## Inspector's Report ABP-320553-24

Whether the replacement of unstable shed to the front of the applicant's property with a shed of similar scale and size, is or is not development or is or is not exempted development.

Poulawaddra, Ballyseedy, Tralee, Co. Kerry

Title: **SITE LAYOUT PLAN.**

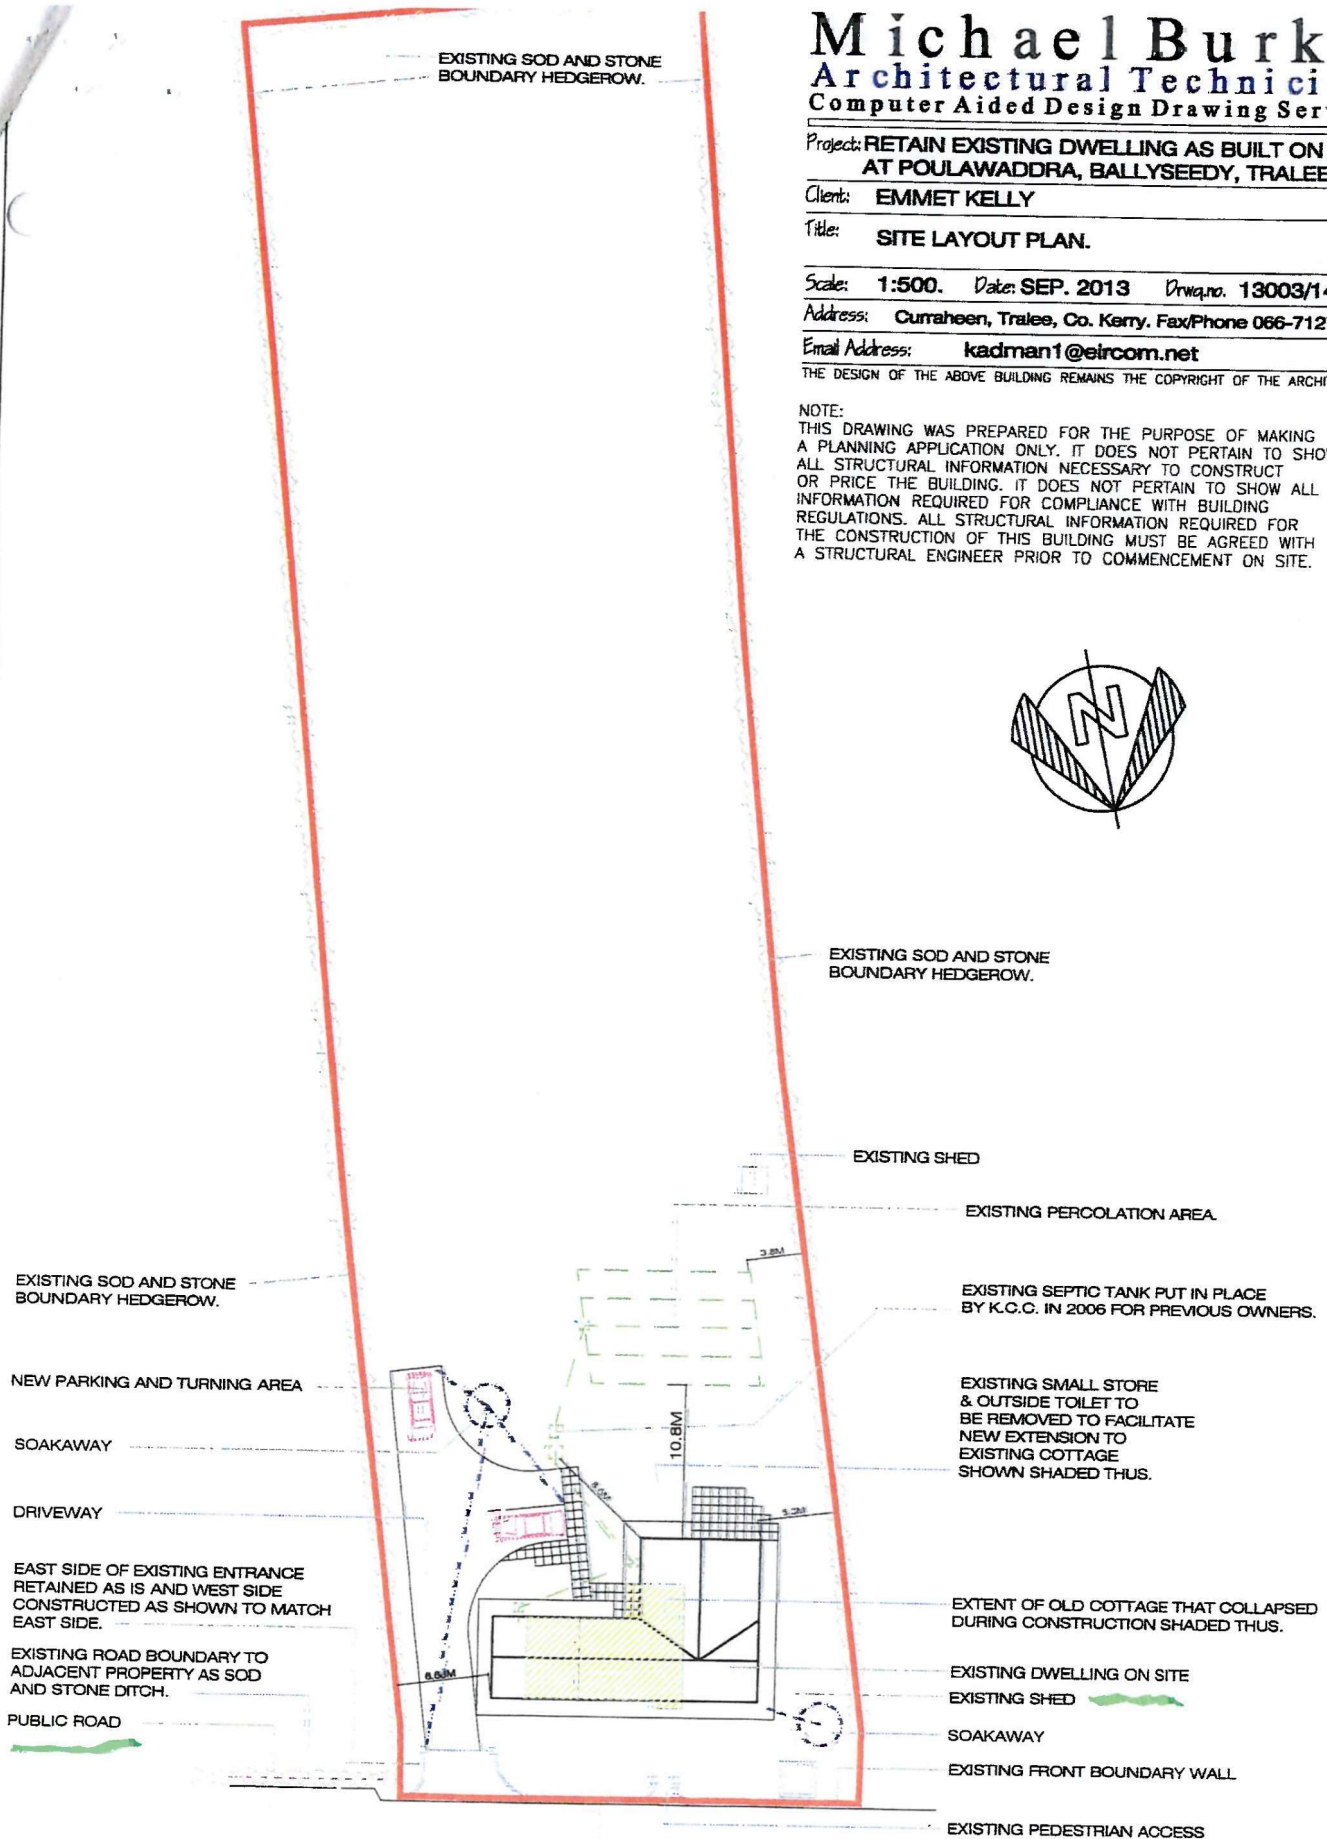
- 8.3.3. Condition 6 of PA Ref. 13/554 (see section 4.0 of this report above) restricts the construction of any part of a garage or other exempted structure (i.e., the new shed if the Board should so deem it) from being built within 4.5m of the centre of the shared boundaries with adjacent properties.

- 8.3.4. From a review of the plans and particulars available on the case file (including the planning history documentation), aerial photographic images, and observations at my site inspection, I calculate that the western gable wall of the new shed structure is c.3.13m to the centreline of the shared boundary with the adjacent property to the west.

- 8.3.5. Article 9(1)(a)(i) of the Regulations revokes the exempted development provisions allowed for under article 6(1) if the undertaking of such development would contravene a condition attached to a permission. As the new shed appears to have been constructed within 4.5m of the centreline of the shared boundary with the western property, I consider the proposal to be in contravention of Condition 6.
